Application for removal or variation of a condition following grant of
planning permission. Town and Country Planning Act 1990.
Planning (Listed Buildings and Conservation Areas) Act 1990

Demolition of existing changing rooms and construction of new changing rooms and community/sports facility

Application reference number: LU/283/11

Condition 2 - As a minor Material amendment to an existing approval LU/283/11.

Rev	Date	By	Revision Notes	Client	Chd	Client	By	TH
A	15/01/11	EW	Revised plan	Southfist Recreation ground	SF	Southfist Recreation ground	By	TH
				Proposed Section AA		Proposed Section AA	Chd	SF
				Drawing Number	1051 (GA) 15	Rev	A	Scale 1:100 @A3
								Date 30/09/11

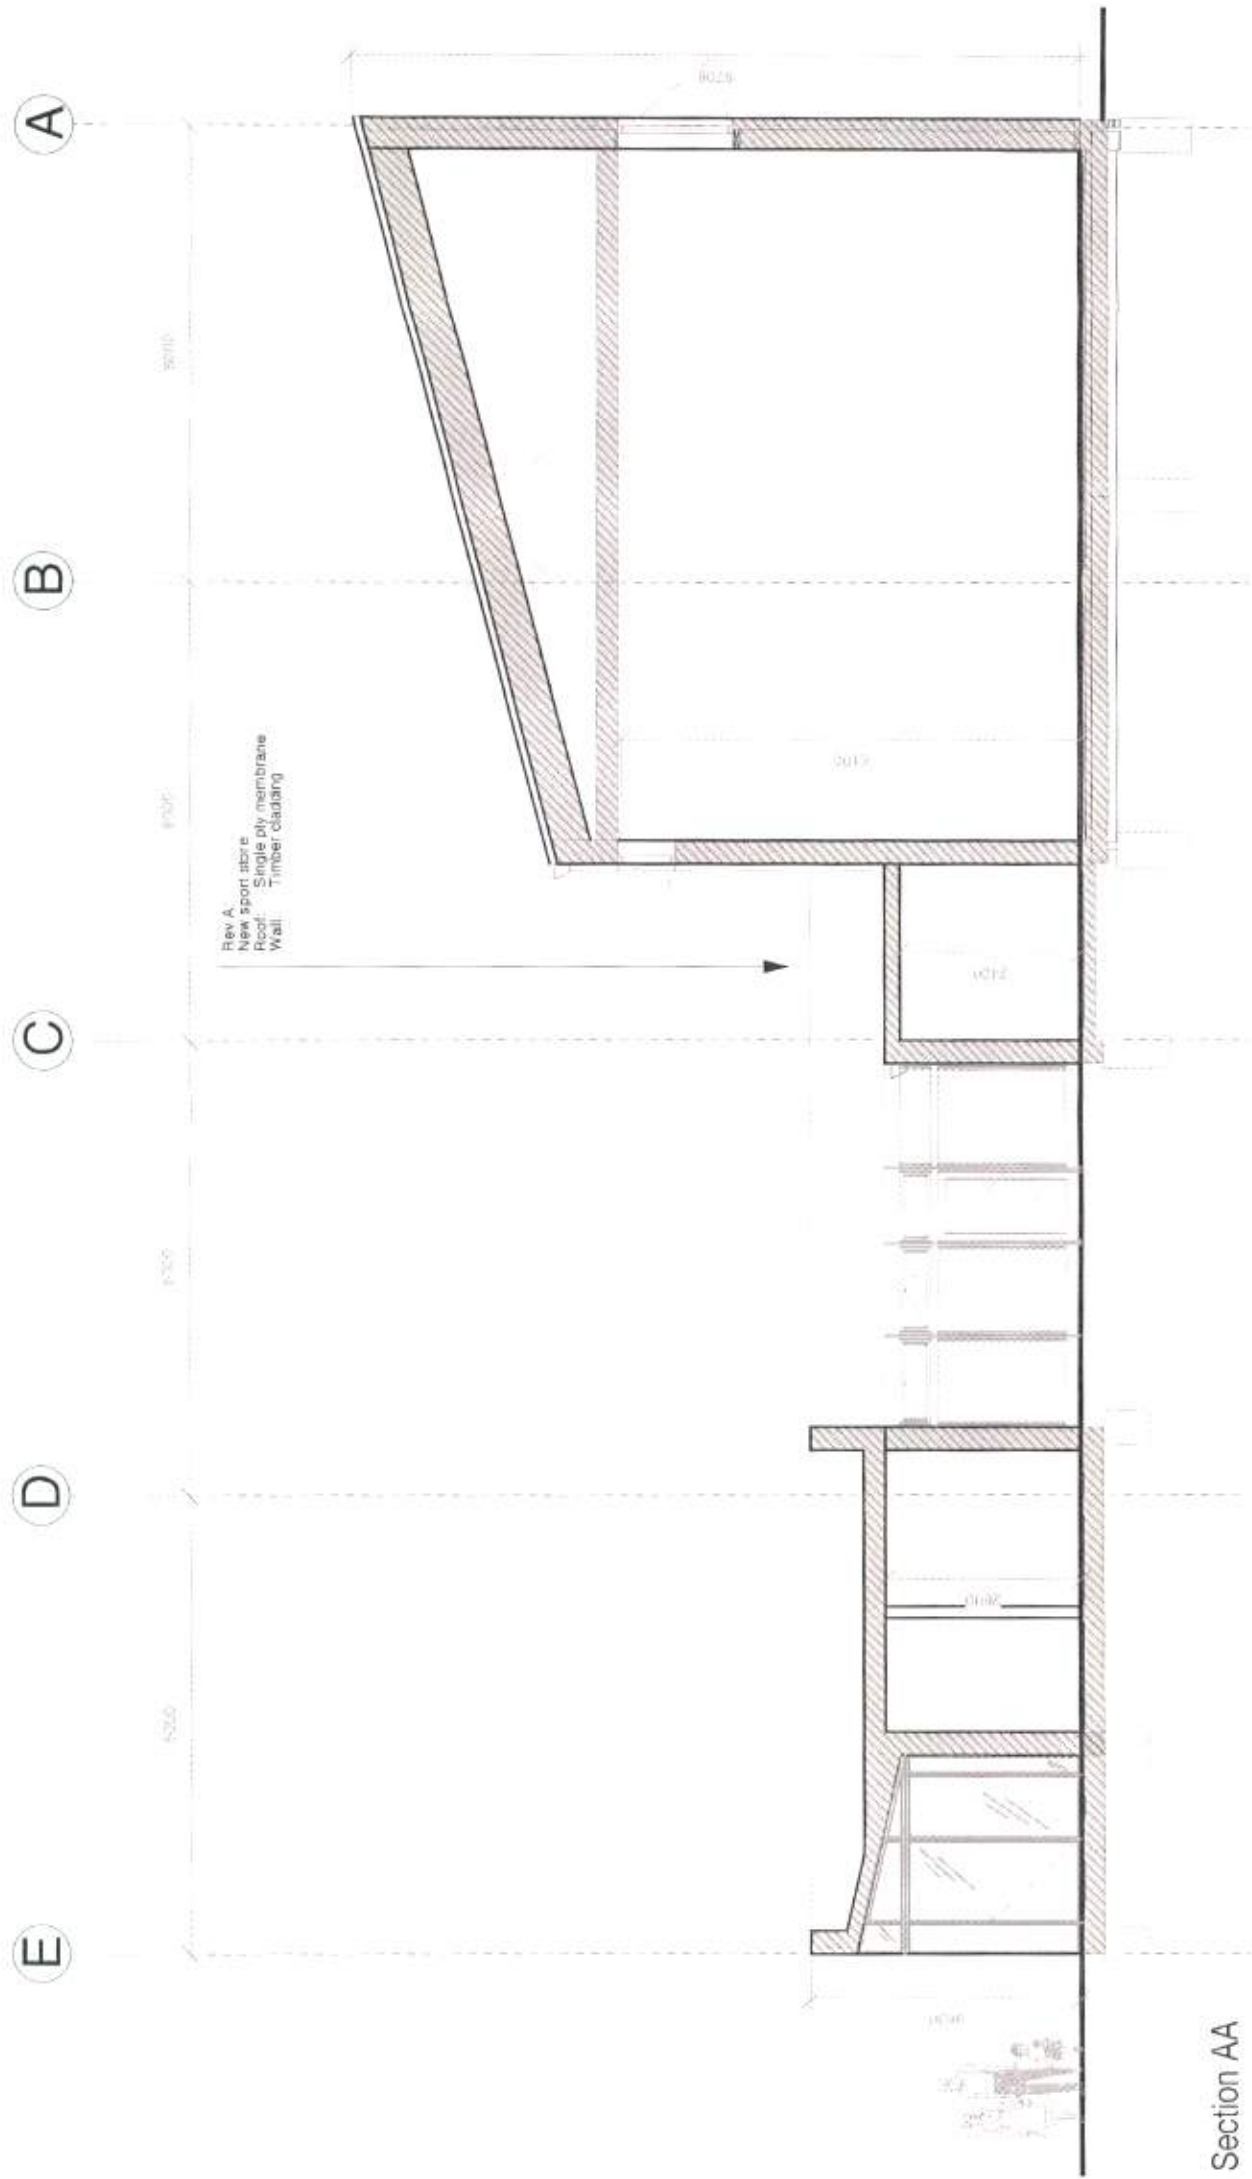
1. Addition of a storage area within the enclosed courtyard (as requested by user groups).

2. Windows alignment and location.

3. External kitchen door.

Please refer to drawings:- 1051 (GA) 03E, 06A, 07A, 15A and 16A enclosed.
